Application at Nursery Fields, Land to the north of Chalcraft Lane, West Bersted (ref. BE/148/20/OUT)

**Appendix 1 Review of i-Transport Modelling prepared by Pell Frischmann
(dated 03 February 2021)**

Pell Frischmann		Project No. A13395
		Version No. Final
TECHNICAL NOTE	Project West Bersted	Date 16/02/2021
Subject Review of i-Transport Modelling		By Chkd S. Moody P. Smith

Submitted Parameter Plan – drawing reference 01304\_Land Use and Access Parameter Plan\_PP\_01\_PI

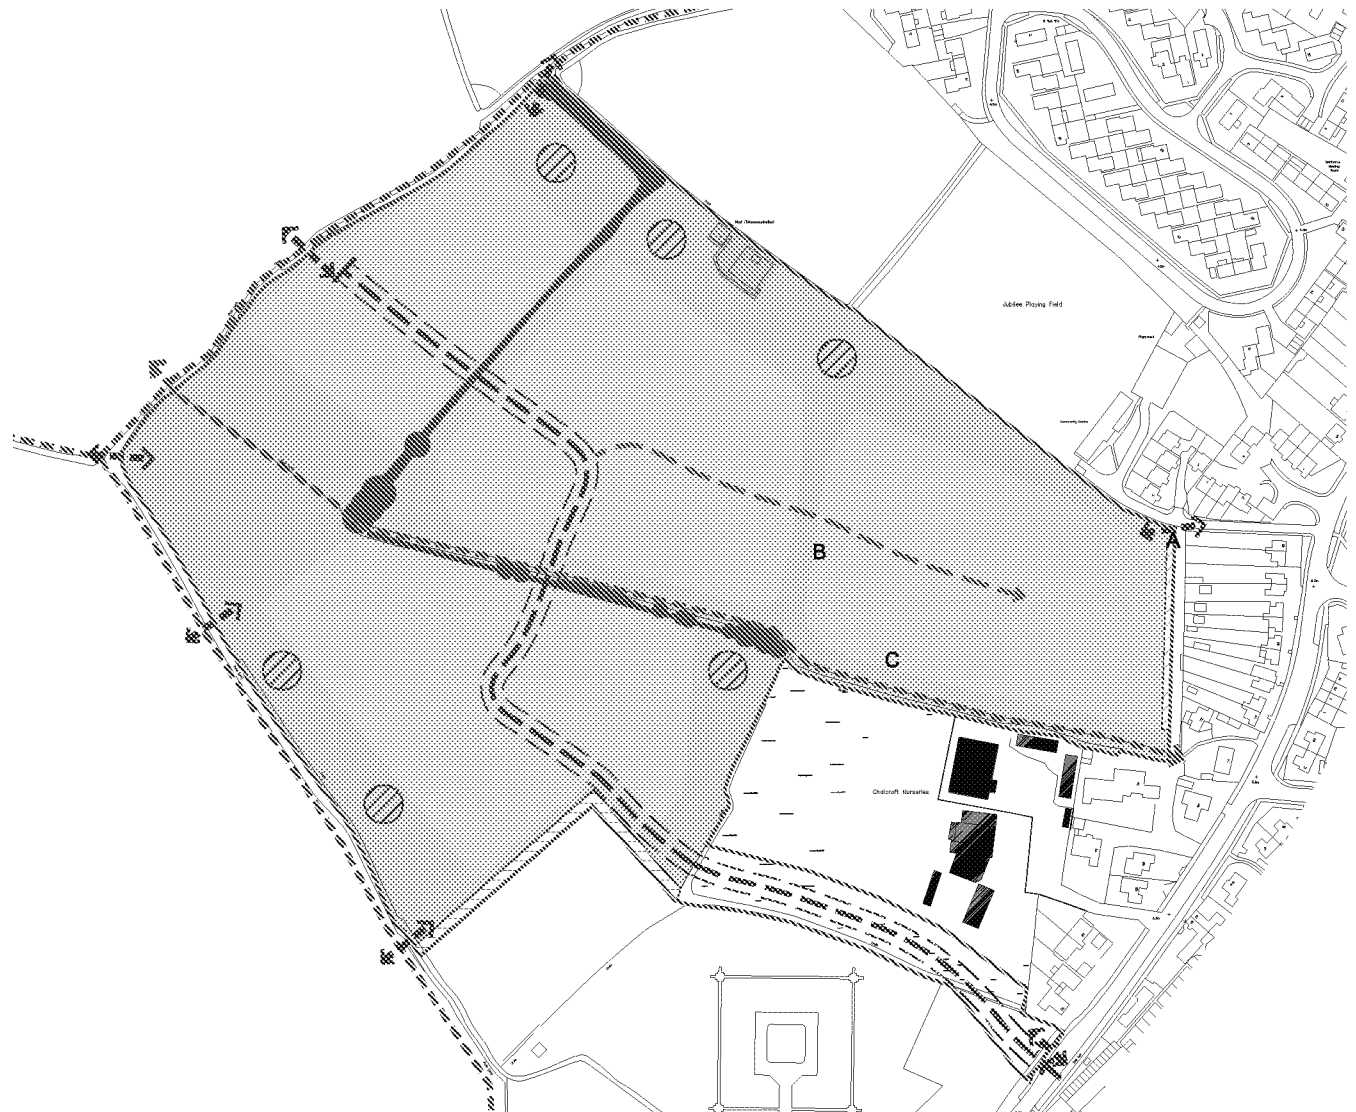
- 3 The application proposals are not consistent with the principles of the Framework Masterplan as it shows a vehicular link between the two ownership parcels. The application shows this as a possible bus/pedestrian link only.
